CITY OF ALBUQUERQUE

February 7, 2017

RE: Townhomes for Greg Lobberegt
Grading and Drainage Plan
Engineer's Stamp Date 2-6-2017 (File: H22D026)

Based upon the information provided in your submittal received 2-6-2017, the above referenced Grading and Drainage Plan is approved for building permit and SO-19 permit.

TYPICAL UNIT PLAN

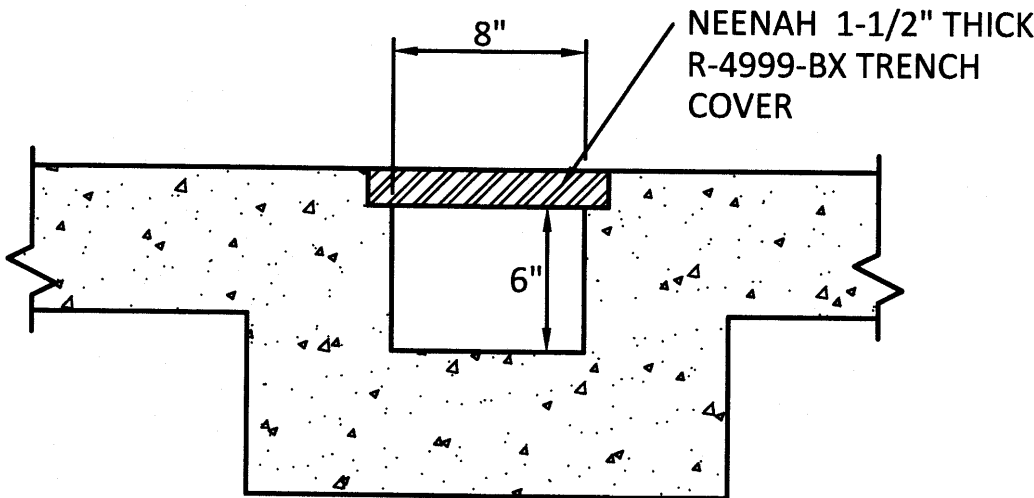
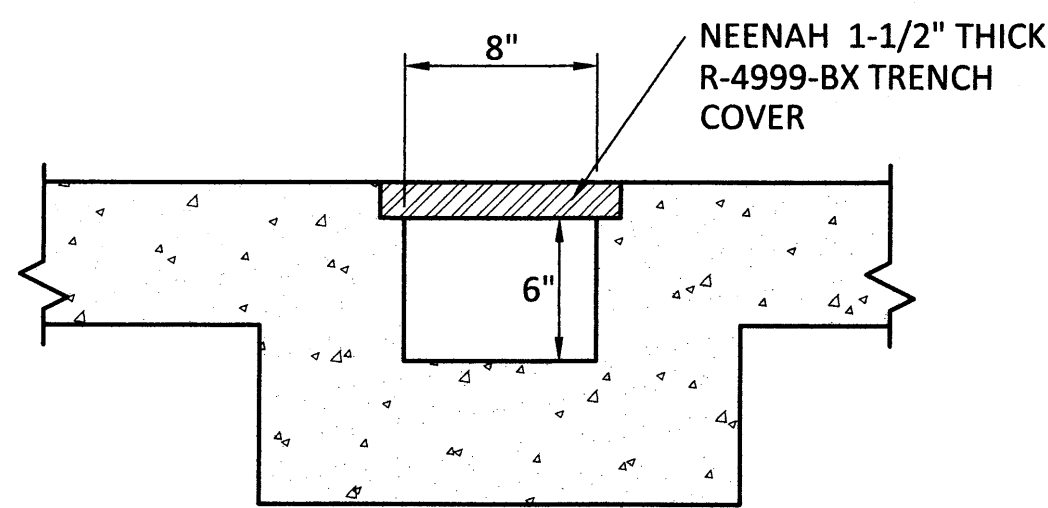
1. Provide a vicinity map.
2. Provide a narrative for offsite flow.
3. Provide back yard details and typical lot layout.
4. Provide first flush calculations for back yard separately from rest of site.
First flush volume for back yard can only be for previous surface in back yard.
5. Provide a curb cut north of the dumpster enclosure for the south east pond.
6. Provide a curb opening at regular intervals along the north side of the site.
7. Depress all landscaping area at the north side of the site.
8. ESC plan and ESC permit is required. (coordinate with a stormwater quality engineer).
9. For town house that backup to the street consider drain them to the street.
10. Extended sidewalk culvert plate 1 foot behind the sidewalk.

- 1-2. Vicinity Map and Offsite flow narrative have been added.
3. Typical unit and backyard detail has been included.
4. The 1st flush volume calculations have been revised.
- 5-6. Additional curb cuts have been noted on the plan.
7. Landscape strip north of access drive has been noted and shown as depressed.
8. The ESC plan is being prepared by others.
9. Backyards of units that back up to public streets are now shown draining to the street.
10. A note has been added requiring sidewalk culverts to be extended 1' beyond R/W line.

DRAWING TITLE: TRAFFIC CONTROL LAYOUT

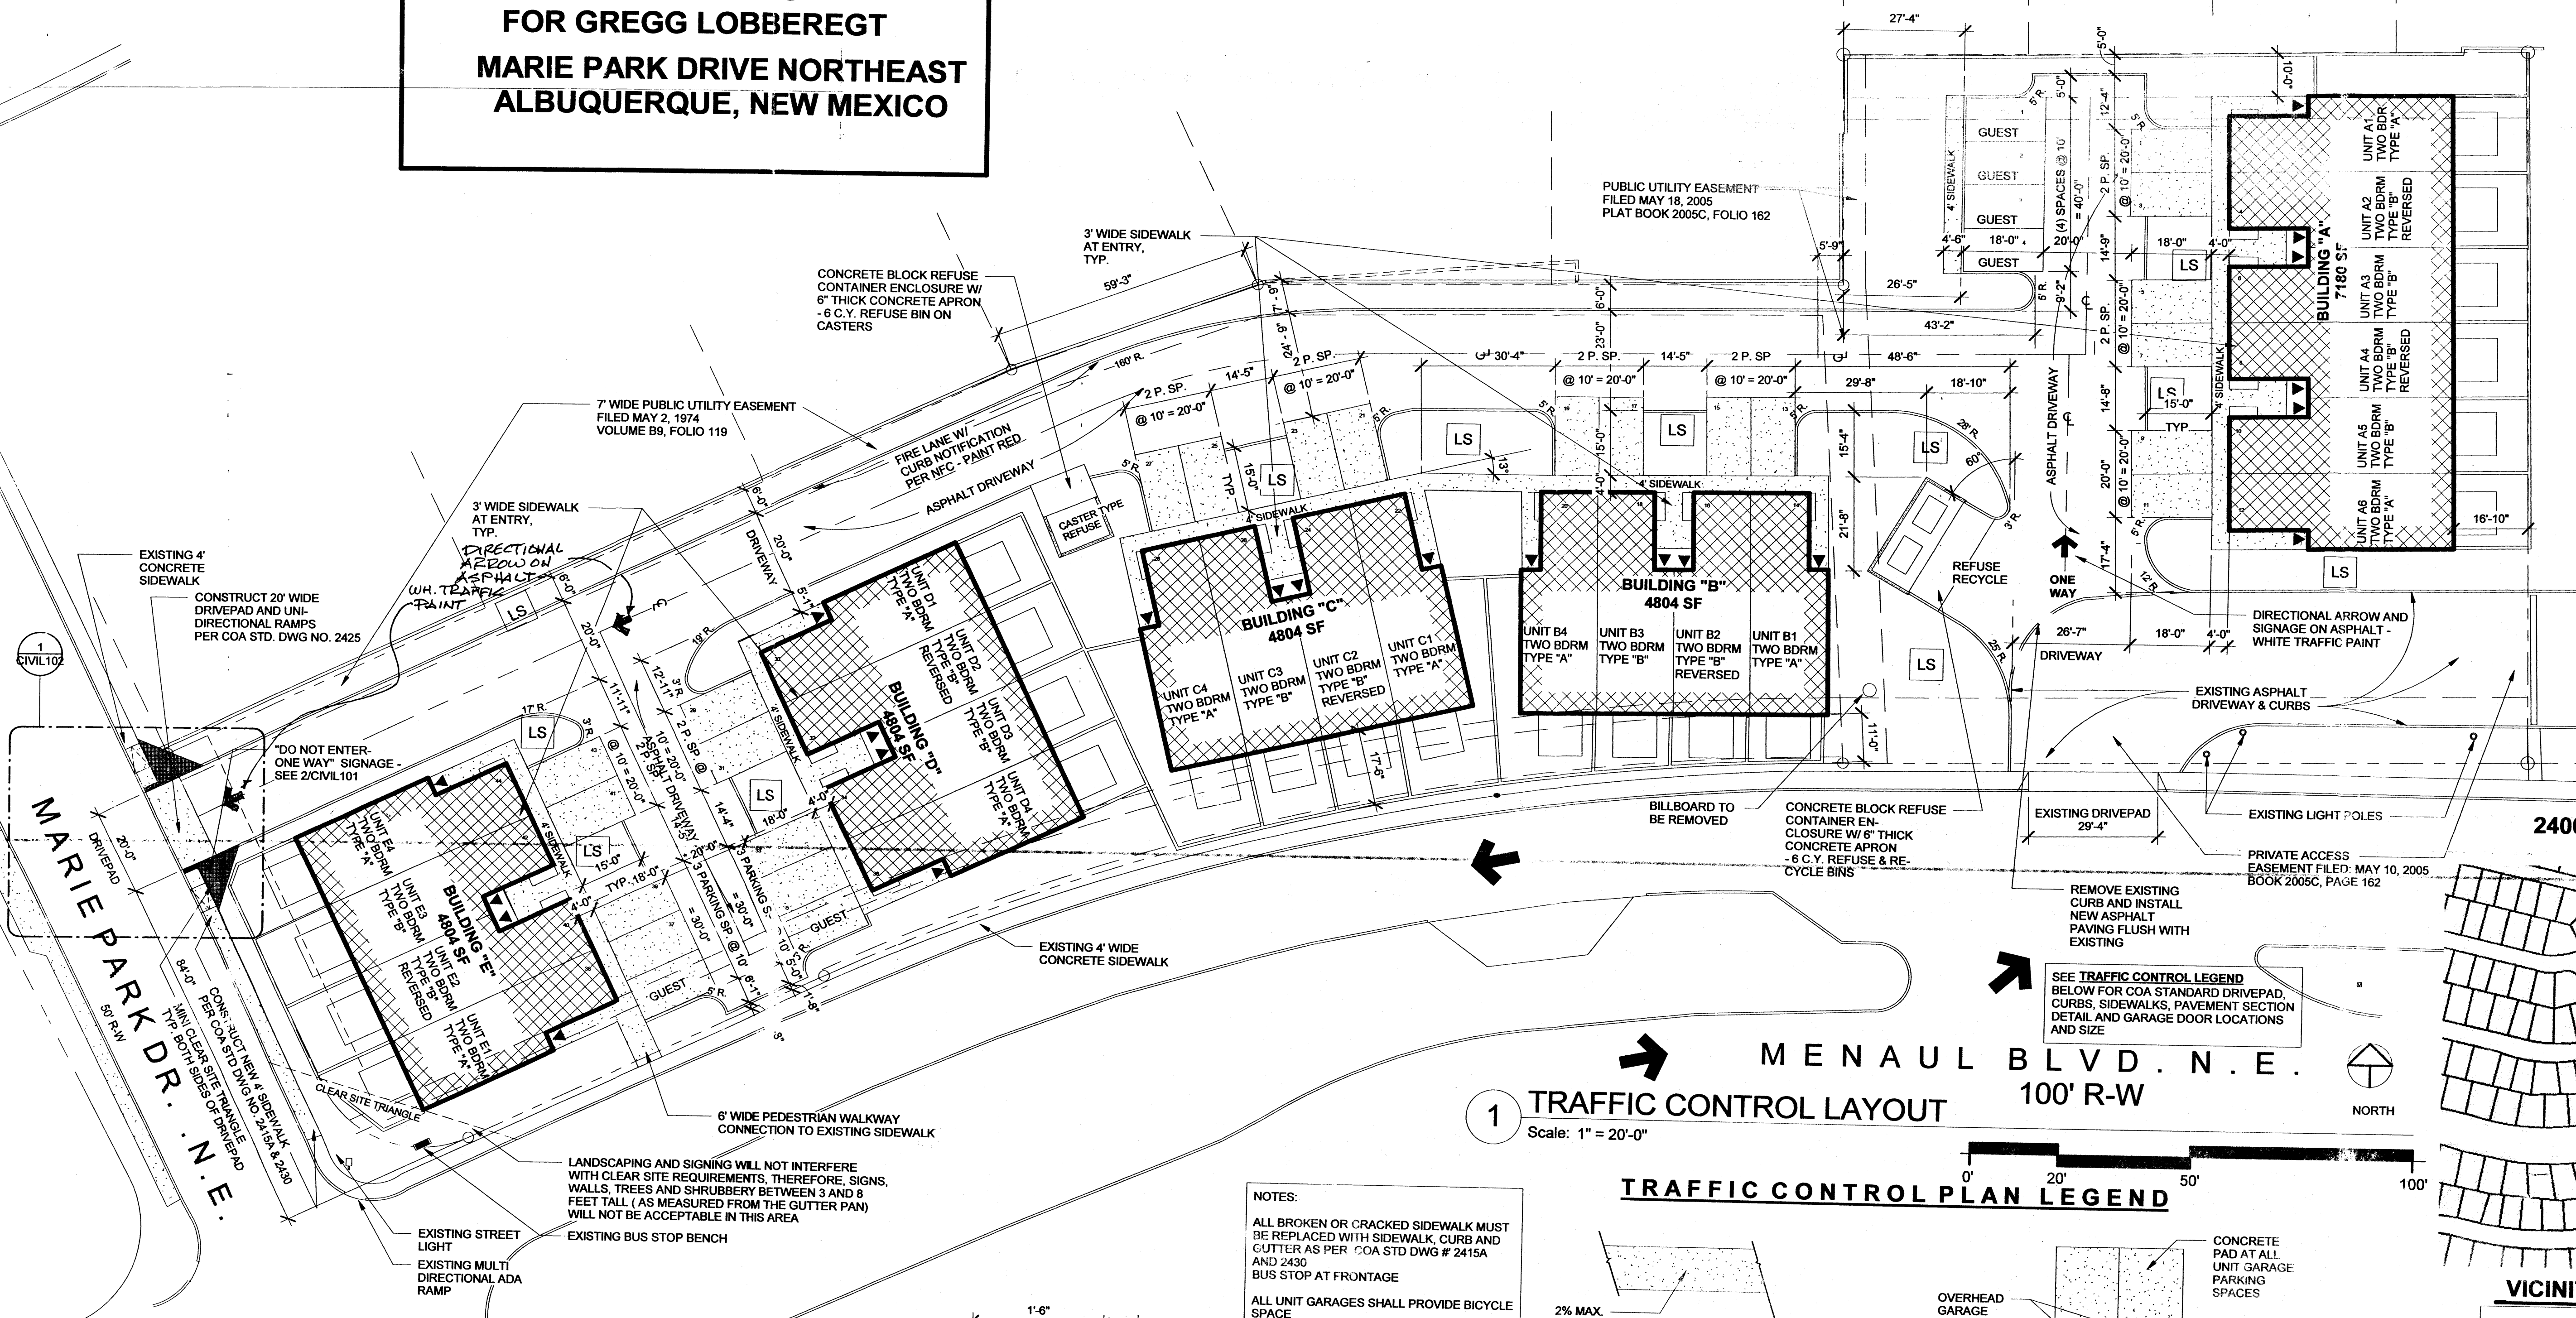
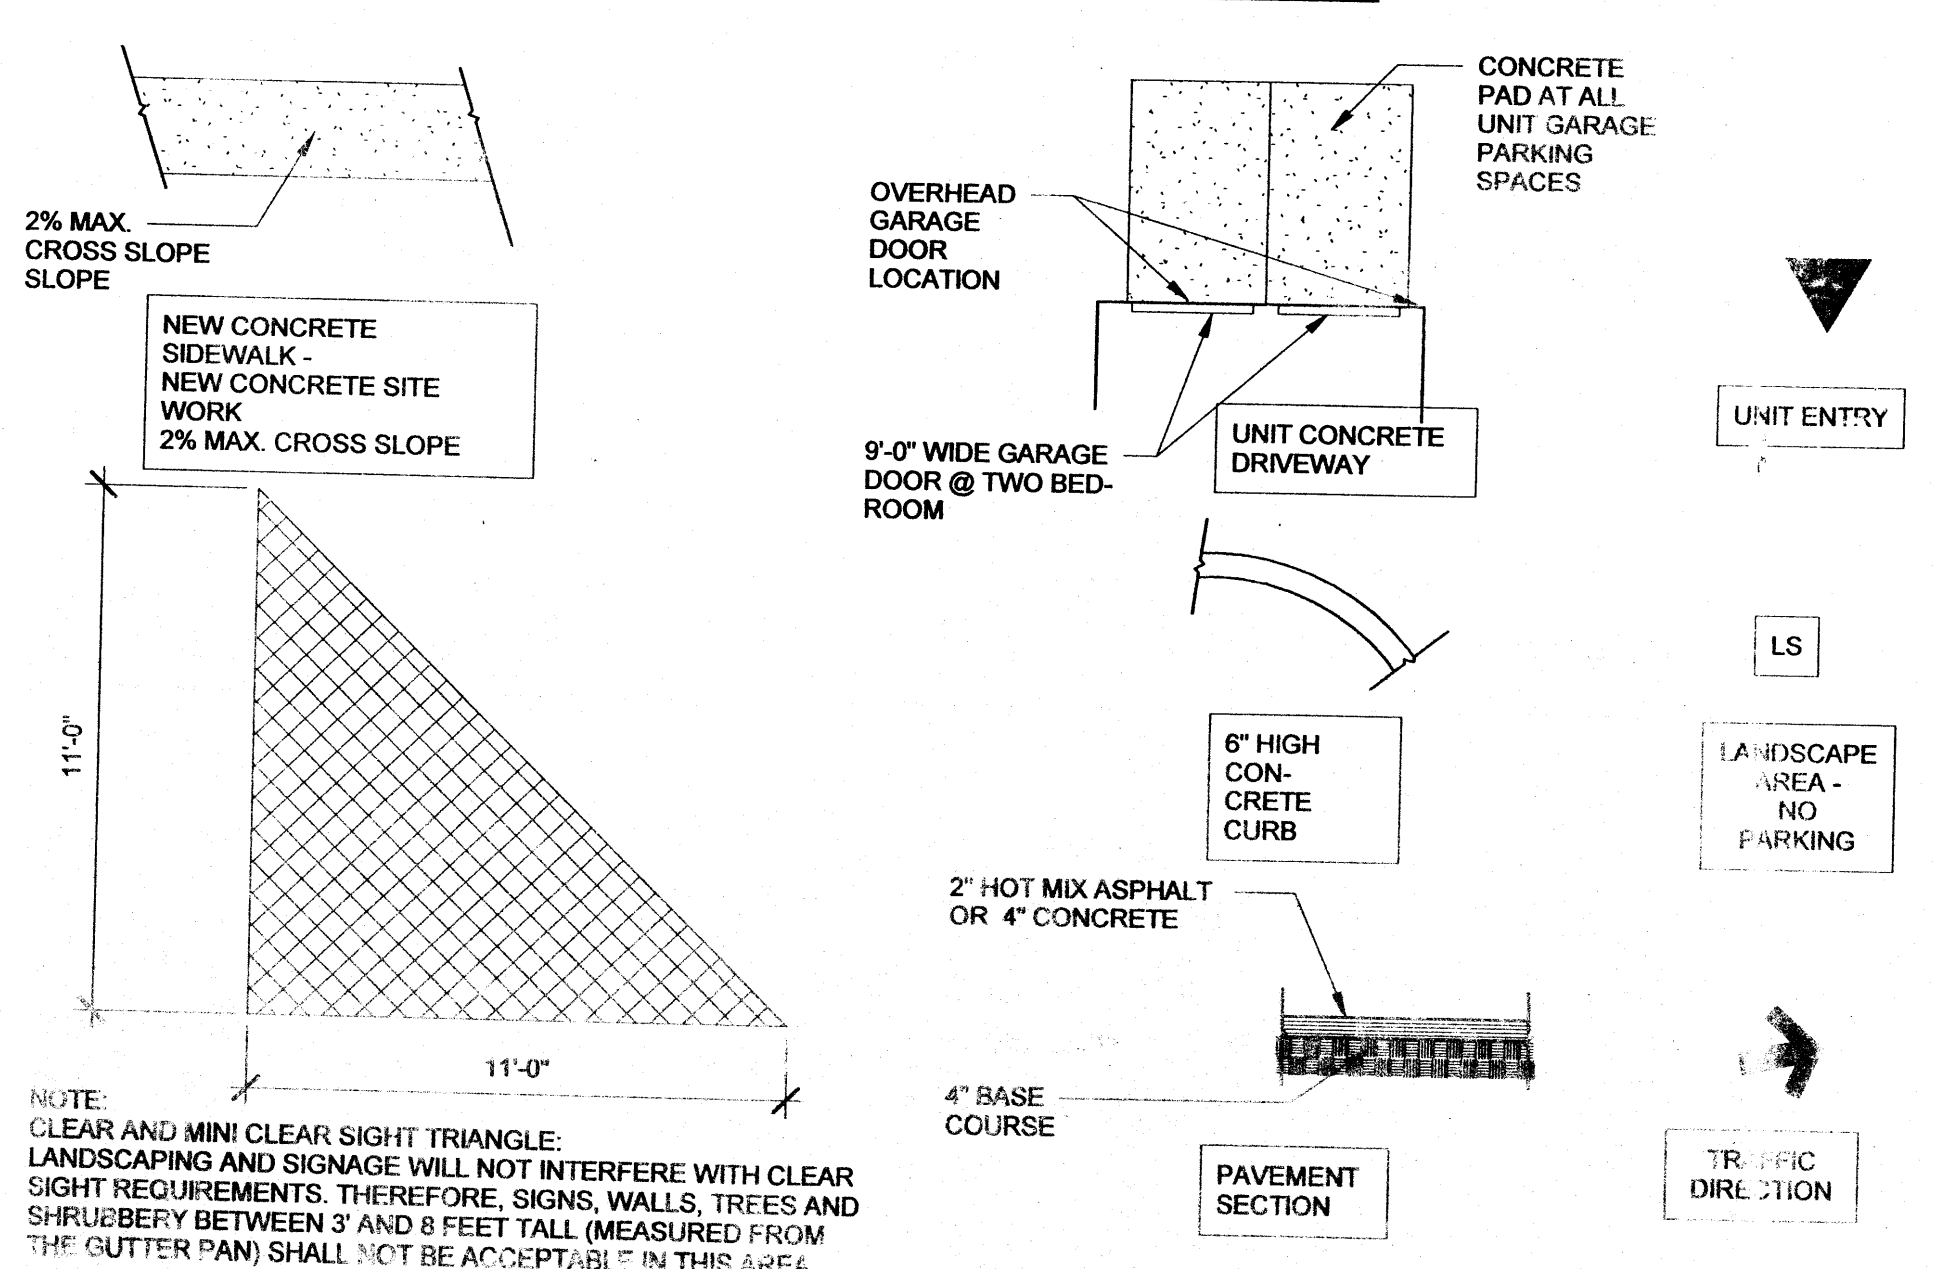
1. The Truncated domes on the second sheet need to be 2 feet wide and should have a note that they will be "Cast-In-Place replaceable".
2. Please add directional arrows at the exit and at decision point along the long road.
3. We will need fire's approval.
